Application No: BR/44/21/PDH
Site Address: 38 Havelock Road Bognor Regis PO21 2HA
Description of works: Notification under extended permitted development rights for a single storey rear extension with mono-pitch roof & roof lantern measuring 8m from beyond the rear wall of the original dwelling house, with a maximum height of 3.8m and eaves height of 3m

Thank you for your internet representation made on 1st March 2021 which has been recorded as an objection with the comments as follows:

Proposed Rear Elevation 1:100

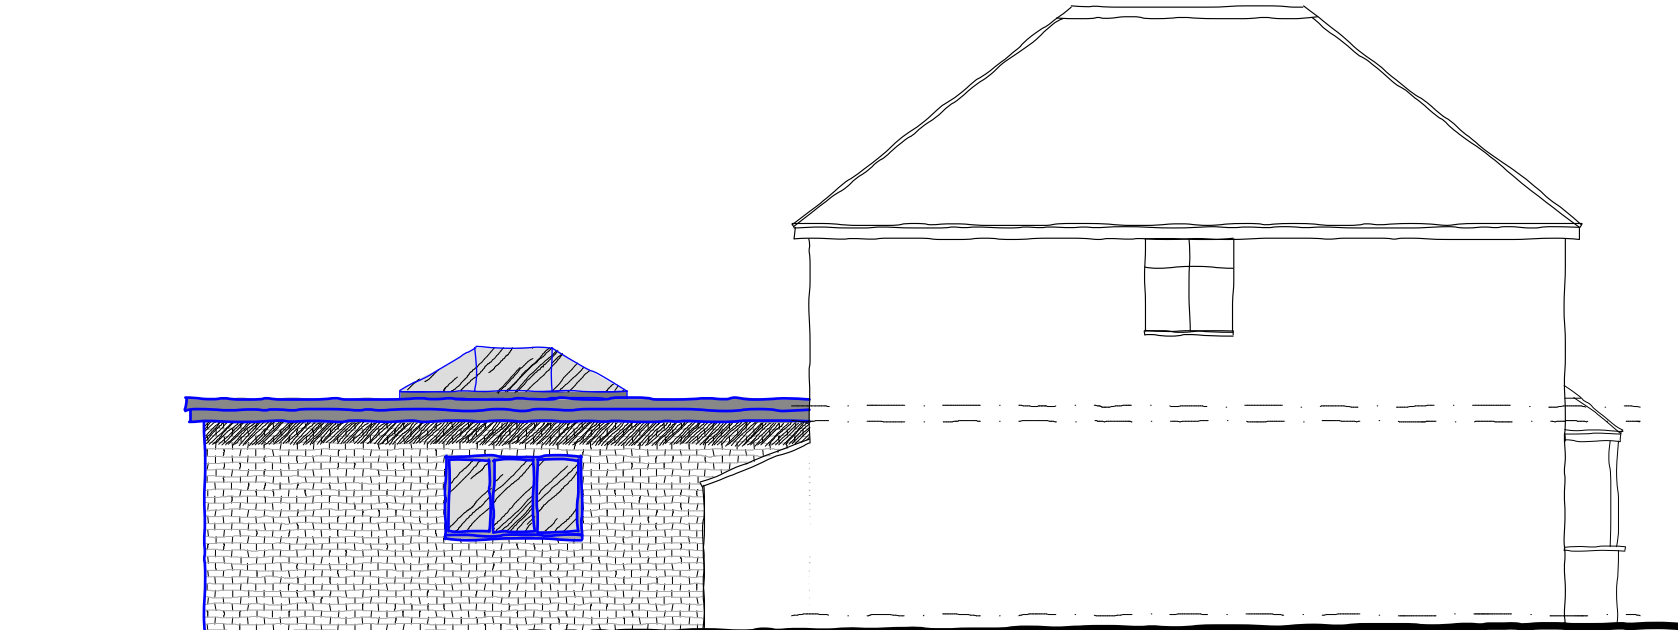
My right to light is completely obstructed by this proposal. I will have no direct sunlight to half my garden after 3pm where I have a patio area. My property 40 Havelock Road has been here since 1930, so this clearly meets the 20 year period required to gain right to sunlight. Also this will make my property less appealing which will reduce the value of my property. The height is the main issue the fact it raises to 3.8m and covers an area of 53.6m² and no consideration is required for surface water drainage. Please can the roof lantern be of a reduced height. I am completely against this application that has no consideration for the residents. Not a single house in the area has a flat roof extension like this application of more than 3m from the rear of the property.

Just to highlight this affects the comfort of my property. Please reduce the height of the roof lantern at least and roof if possible. Can there be a consideration for surface water drainage that will cause flooding issues.
